KIRKLEES METROPOLITAN COUNCIL INVESTMENT & REGENERATION SERVICE

DELEGATED DECISION TO DETERMINE PLANNING APPLICATIONS

Reference No:	2026/62/90222/E
Site Address:	16, Bevor Crescent, Heckmondwike, WF16 9AR
Description:	Erection of single and two storey rear extension and two storey side extension
Recommending Officer:	Jennifer Booth

DECISION - REFUSED

PROPOSED GROUND FLOOR PLAN

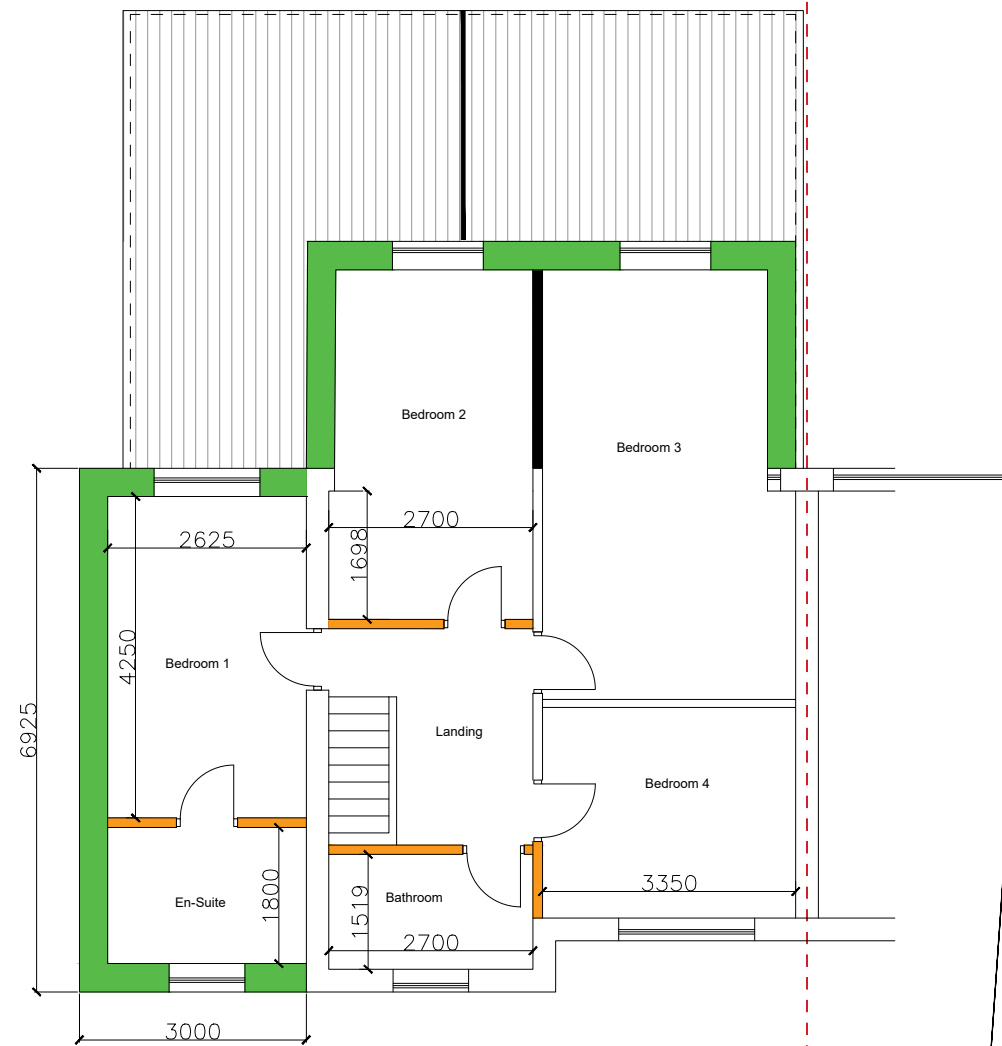
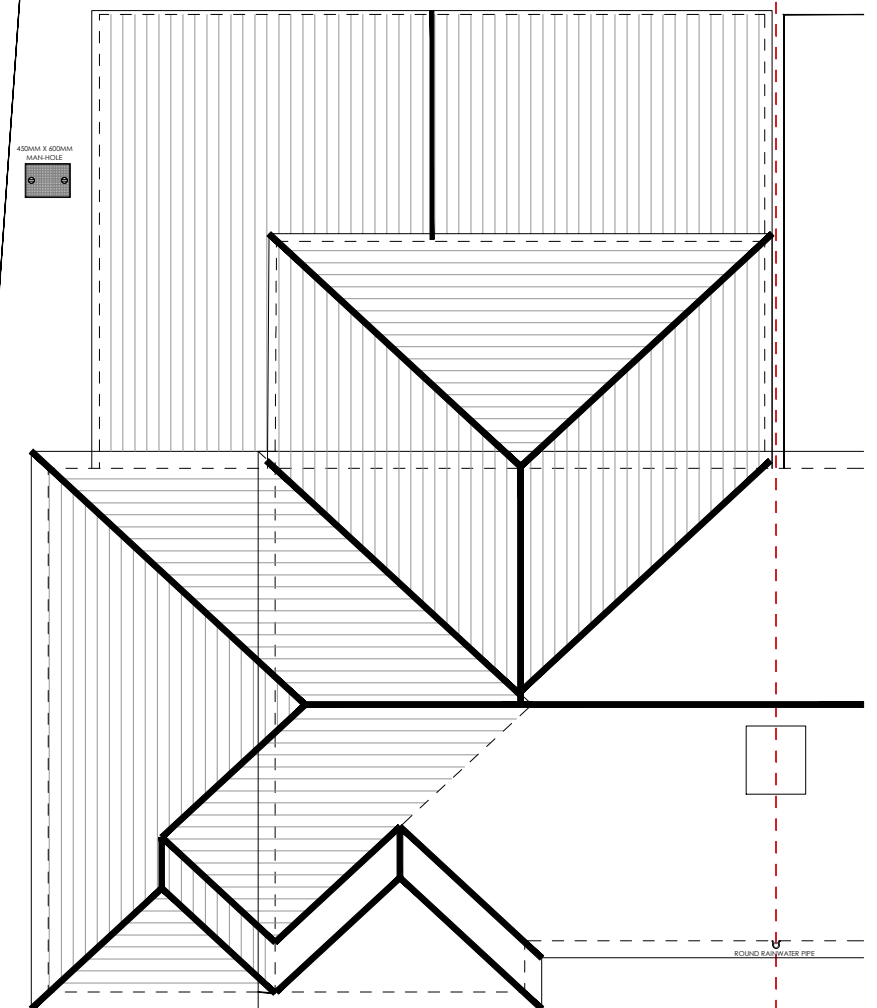
The rear extension would be constructed along the shared boundary and would likely result in some overshadowing and overbearing. Whilst the ground floor of the rear extension has already been agreed through the larger home notification scheme, the first floor element is a new addition and would infringe the 45 degree guidelines, thereby resulting in an overbearing and oppressive impact on the bedroom window of the adjoining property as well as

overshadowing in the morning with no mitigating factors. The windows in the rear would look into the applicants own amenity space with limited potential to overlook the neighbouring property.

The proposed first floor rear extension, by reason of its projection and position along the shared boundary with the adjoining dwelling would result in an overbearing and oppressive impact along with overshadowing in the morning on the bedroom window of the adjoining 14 Bevor Crescent. To permit the proposals would be contrary to Policy LP24 of the Kirklees Local Plan, KDP5 & KDP6 of the House Extensions & Alterations SPD and Chapter 12 of the National Planning Policy Framework.
